Ducy Stables and Riding Academy, PPR-19-027

Please accept the following comments from El Paso County Public Health regarding the project referenced above:

PCD FILE Nos PPR-19-027 and AL 19-016

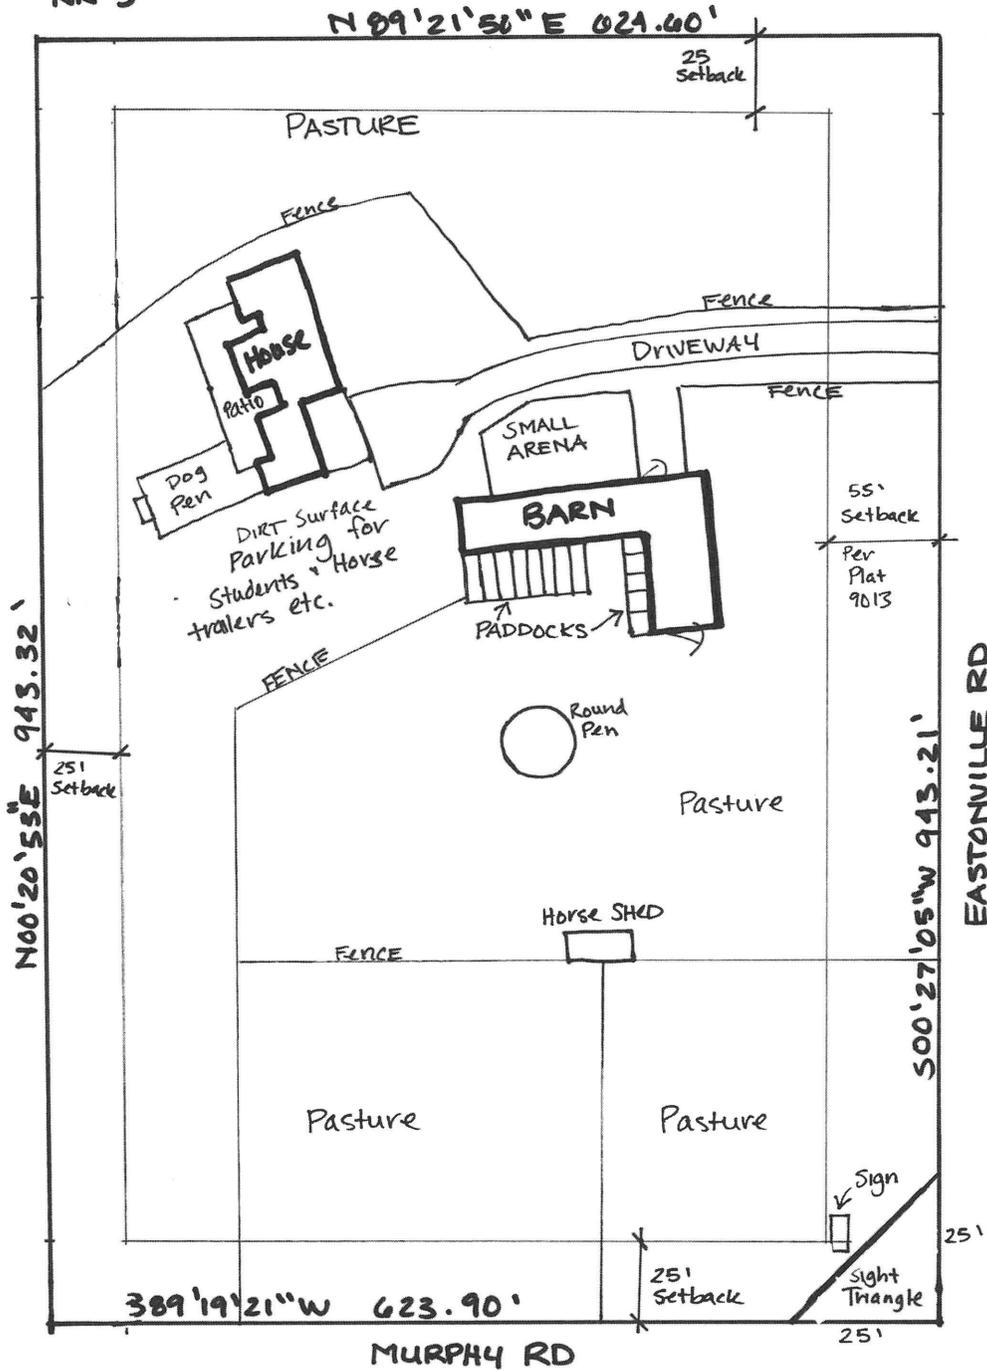
- Restroom facilities were not addressed for customers and employees in the submittal. If the existing OWTS that is connected to the house and barn is planned for customer use, then a professional engineer must evaluate the OWTS for the anticipated wastewater flow increase. The evaluation must be submitted to El Paso County Public Health for review and approval.

- Note: Portable toilets are approved for temporary use only.
- Please assure all components of the OWTS are located and protected from vehicular traffic, livestock and other means of compaction. A secondary site on the property must be preserved for the possibility of a repair, addition, or replacement of the existing soil treatment area. Fencing is preferred but other area identification methods accomplishing the same goal are approved.
